DECISION DELEGATED TO HEAD OF PLANNING

Application No:	H14-1032-21	Applicant:	Executors of P J Borst Deceased c/o G B England Esq
Proposal:	Residential Development - 16 Dwellings - outline approval H14-0912-17		
Location:	Crossgate Lane Pinchbeck Spalding		
Terminal Date:	24th February 2022

Drawing No.
OIM

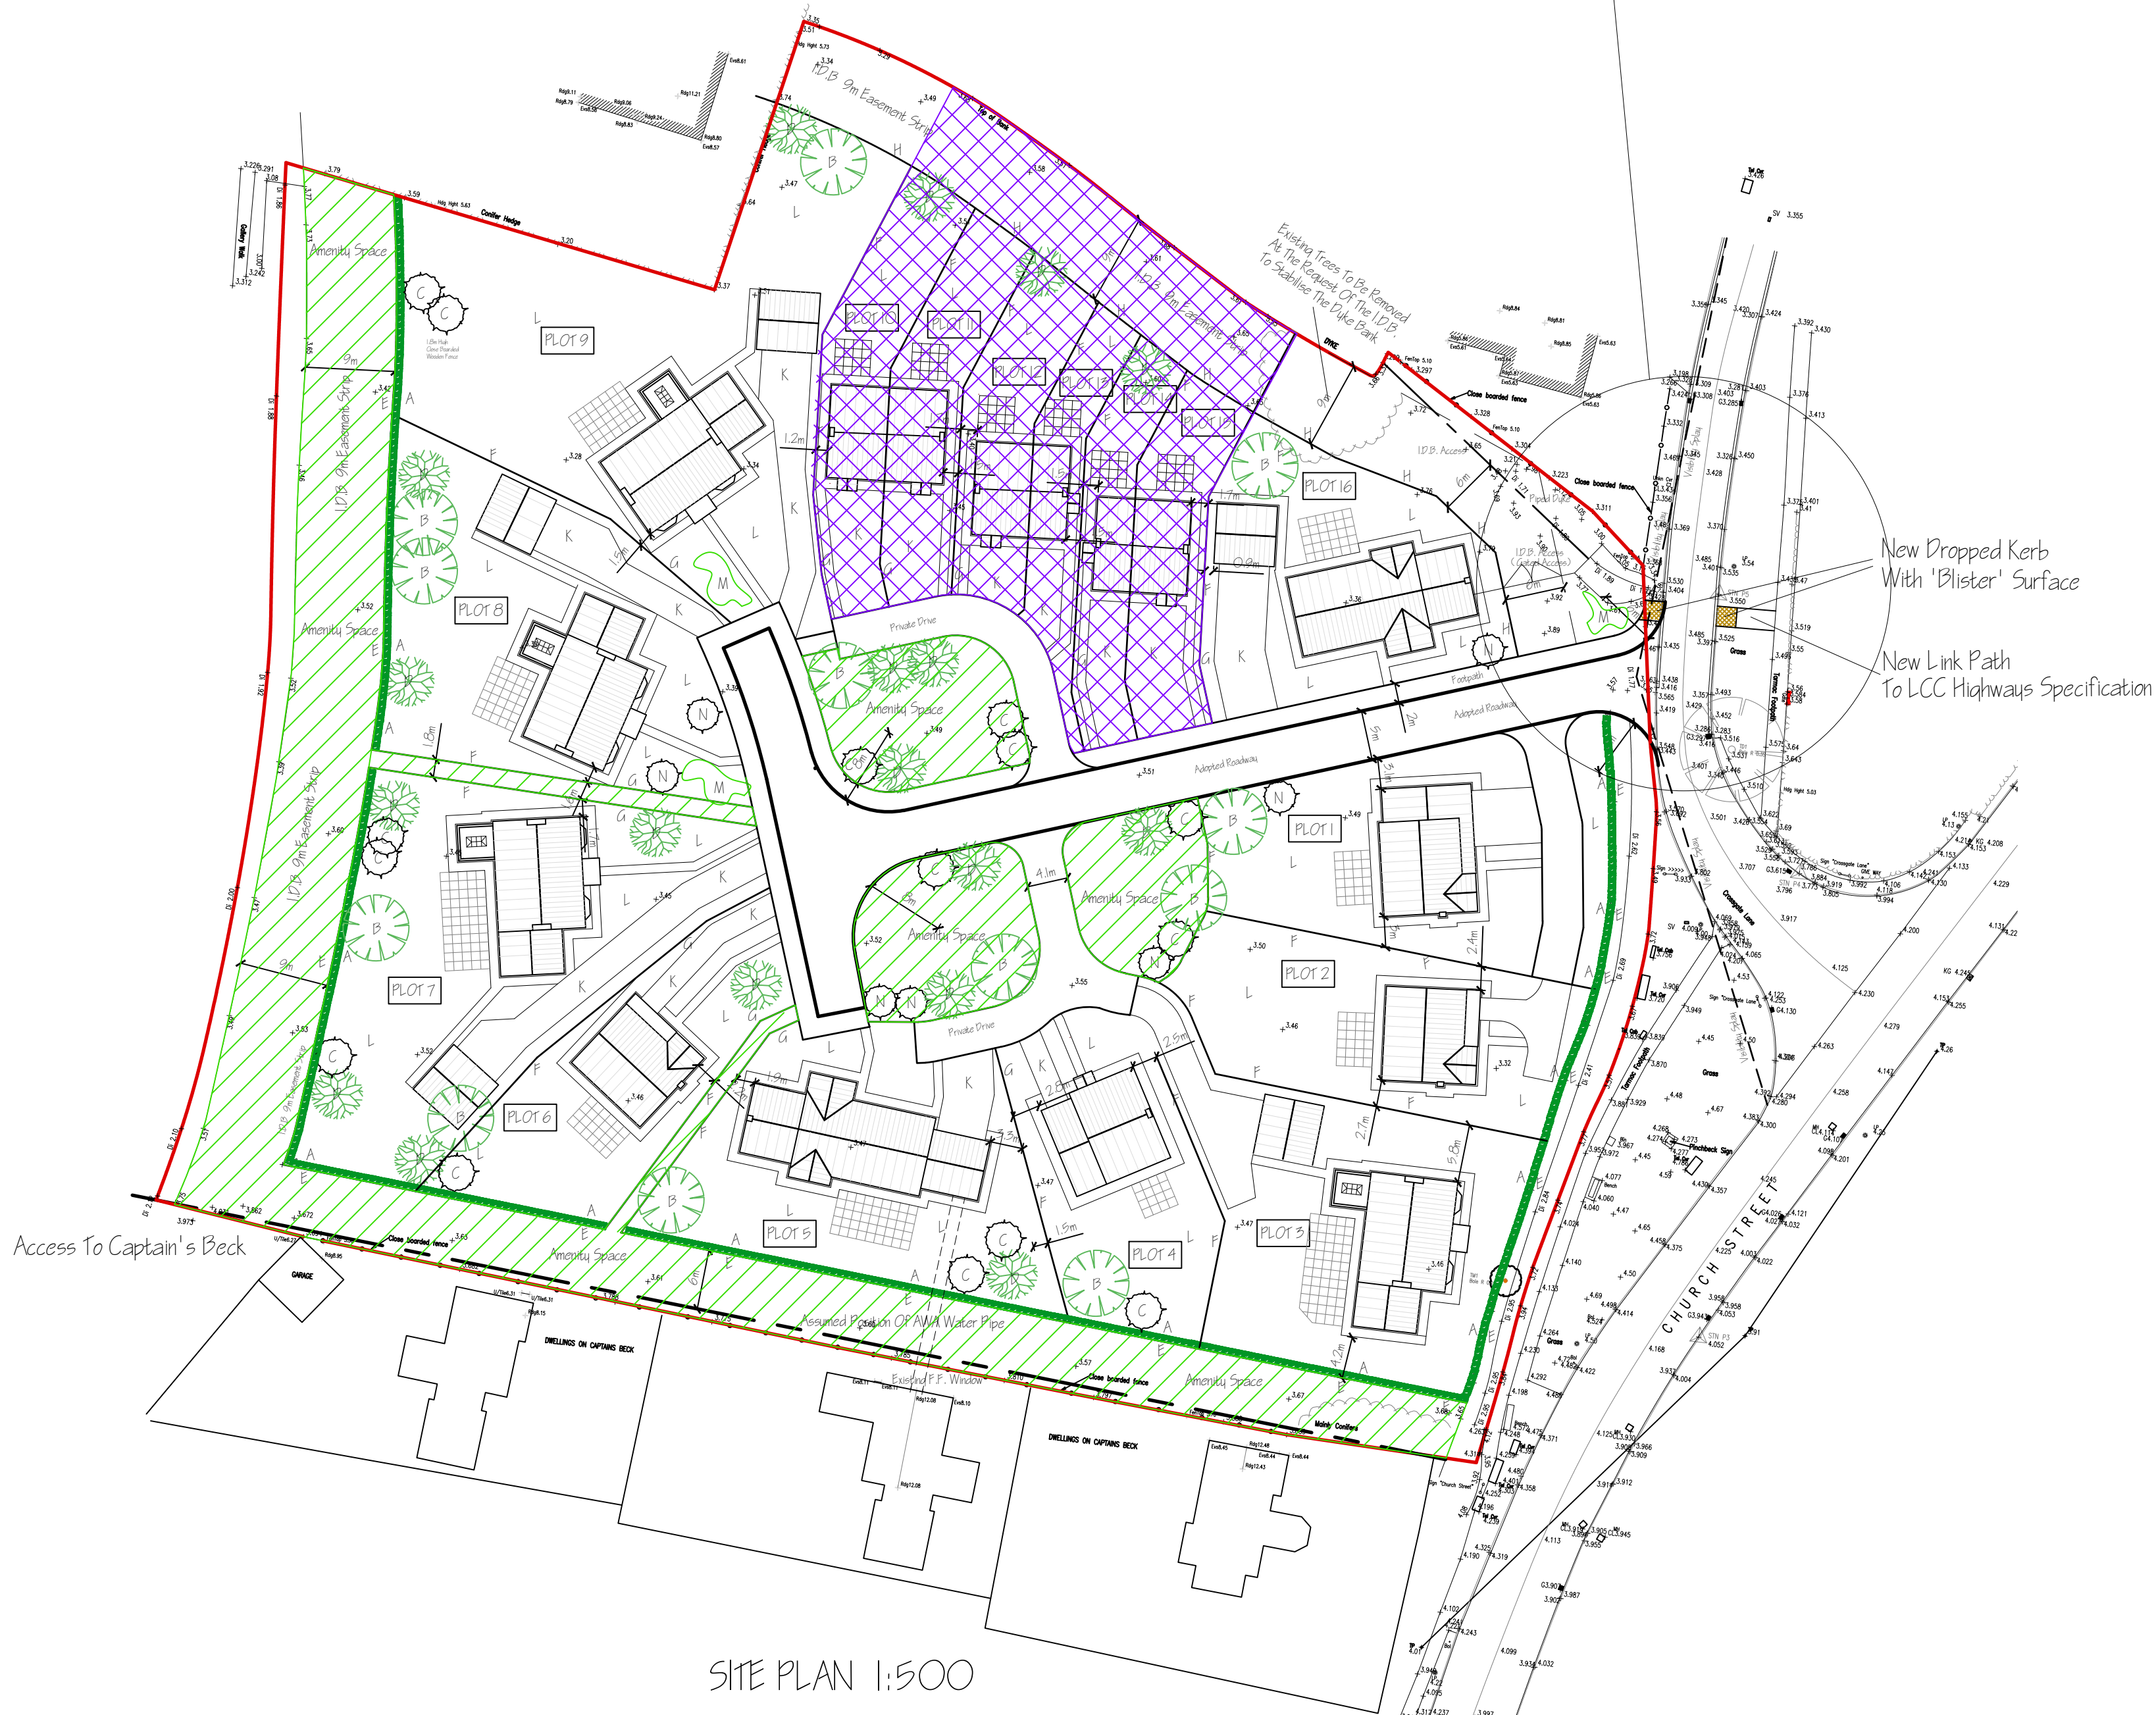
A revised Drainage Strategy will therefore need to be prepared and submitted for approval. Also, can the Applicant/Designer be asked to include a continuous footway link between the proposed development and the existing village footway network.

No objection subject to a condition regarding the footway link across the highway verge on the east side of Crossgate Lane being provided, and informatives.
